EPC STORMWATER REVIEW COMMENTS ARE SHOWN IN ORANGE BOXES WITH BLACK TEXT

# YUCATAN CONVENIENCE STORE

## GRADING AND EROSION CONTROL PLANS

4815 YUCATAN DRIVE, COLORADO SPRINGS, EL PASO COUNTY, COLORADO

SHEET
C1.1

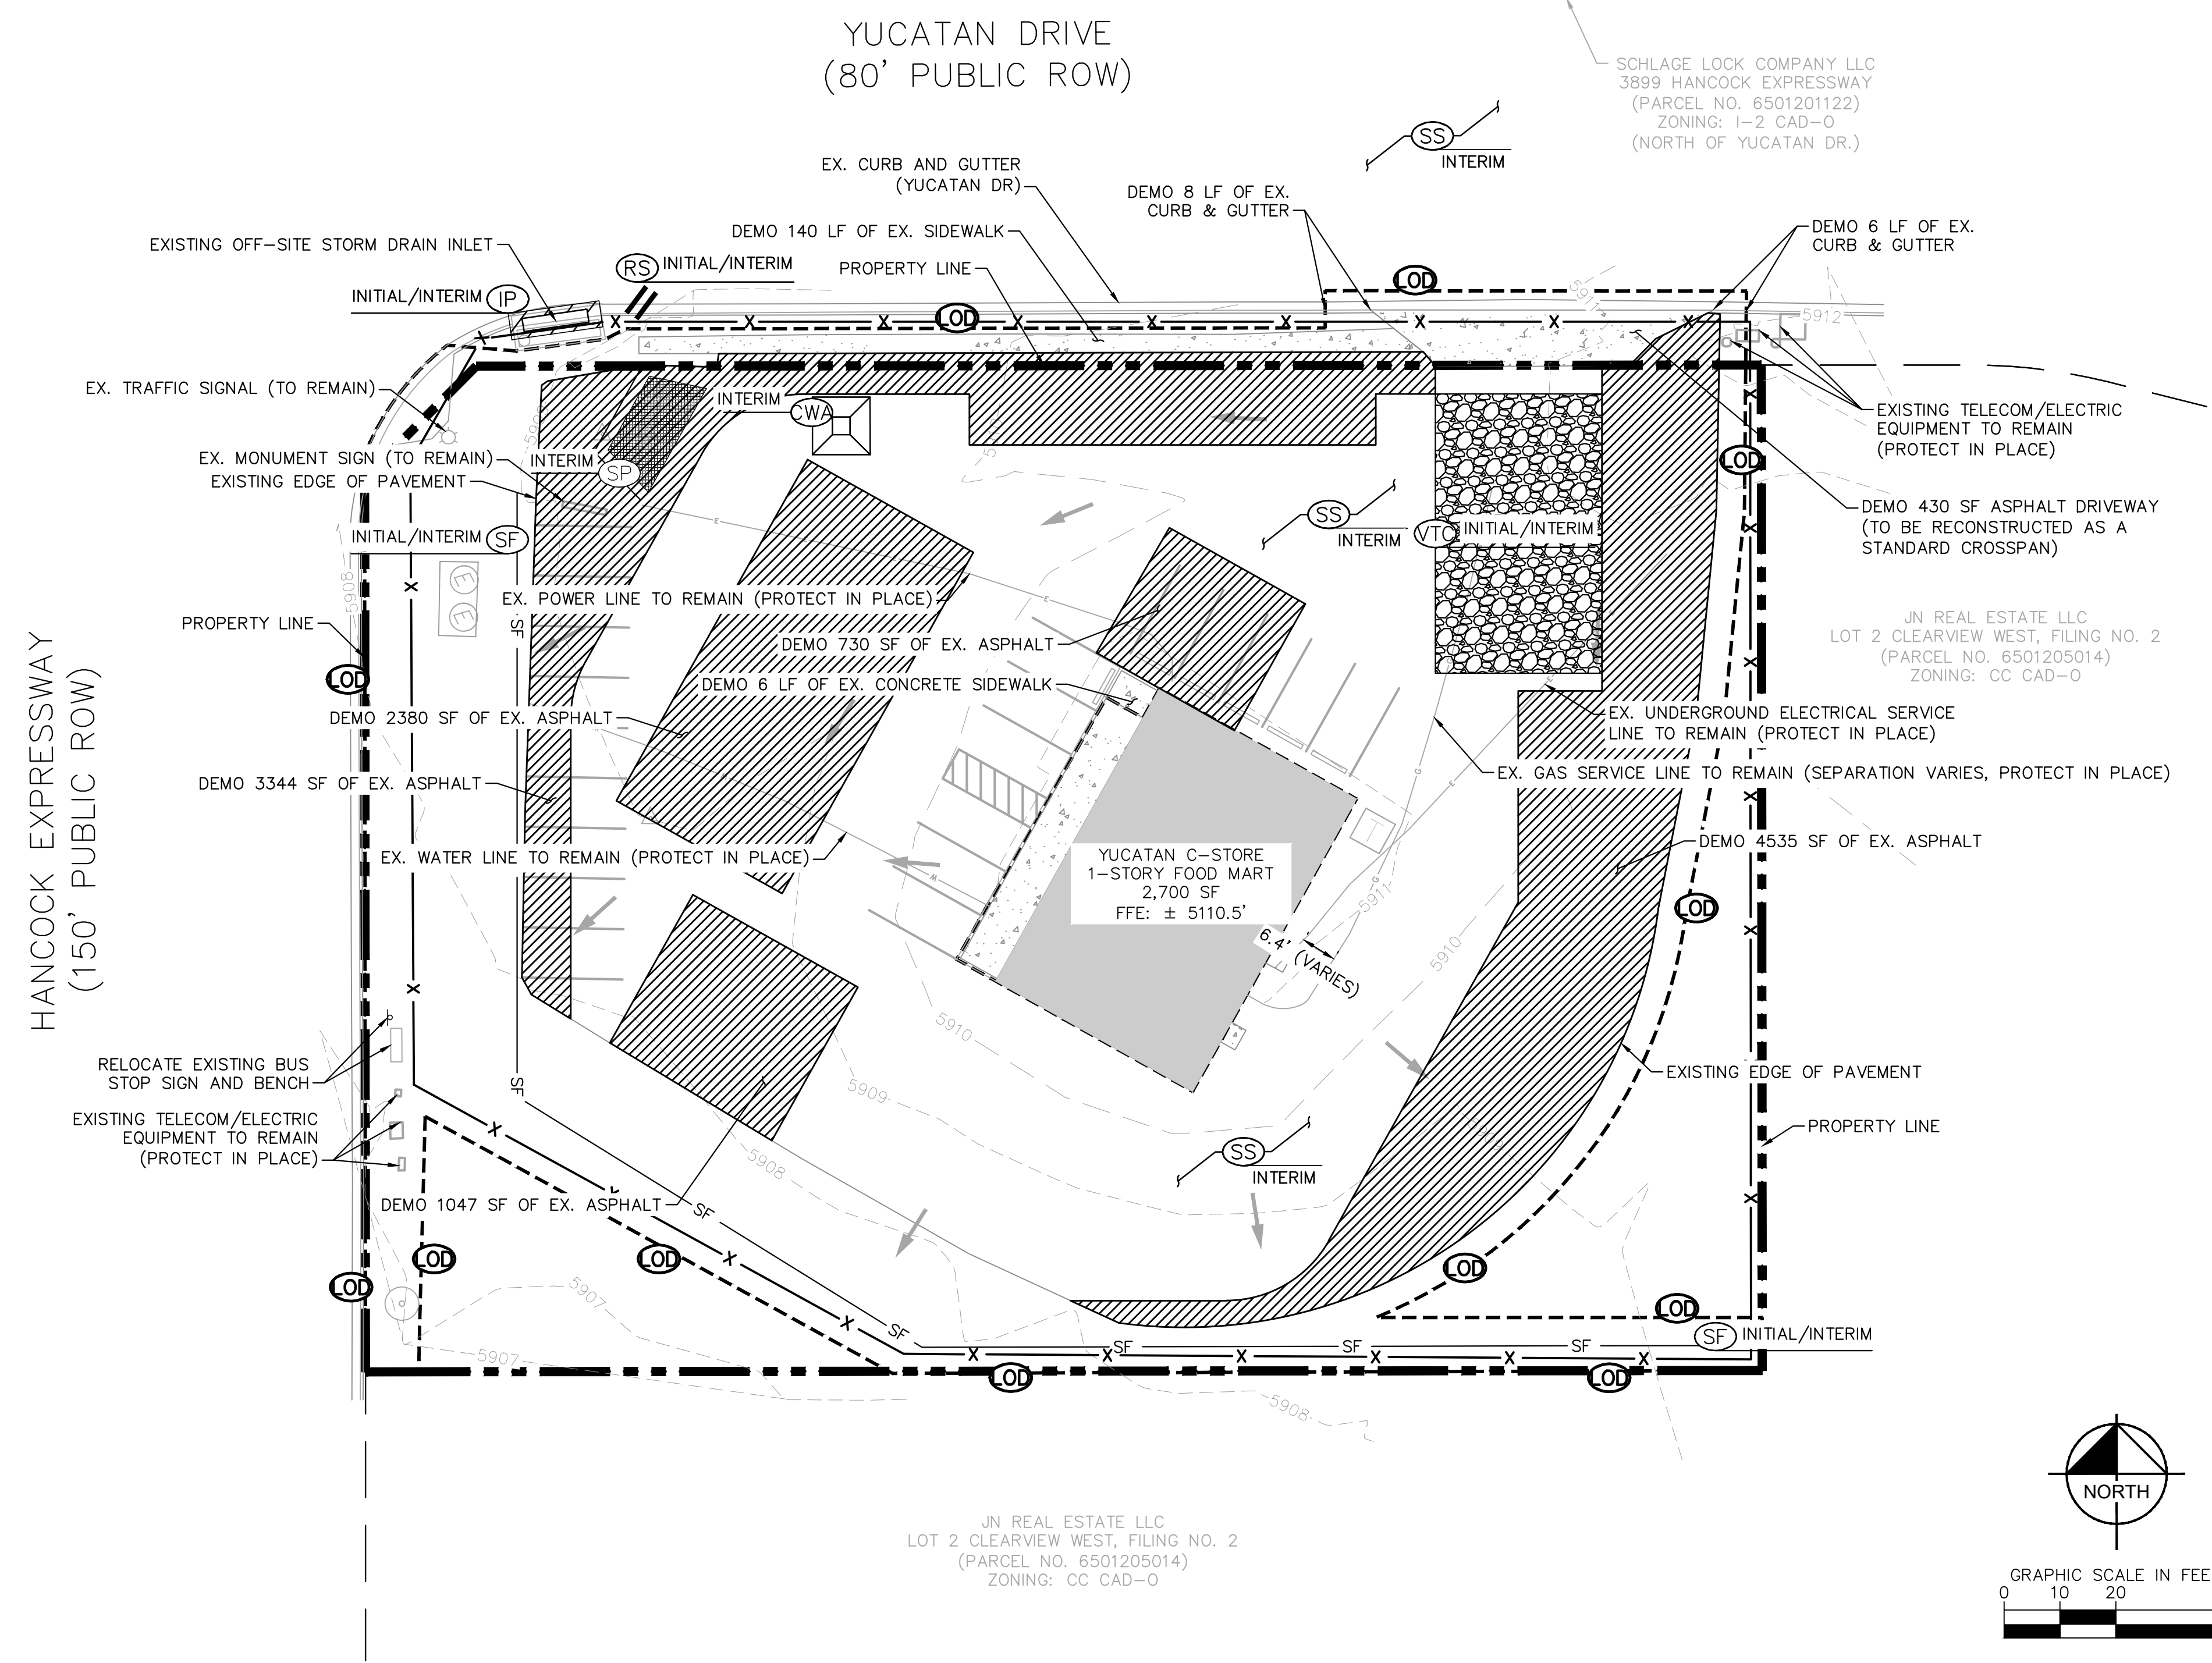
It looks like the plans changed a bit from the last review. If you're just removing and replacing asphalt and there is no proposed cut/fill, please just add a note to the plans stating such and remove highlighted text.

If there are areas of proposed cut/fill, show line work on figure and clearly indicate which side of the line is cut and which side is fill
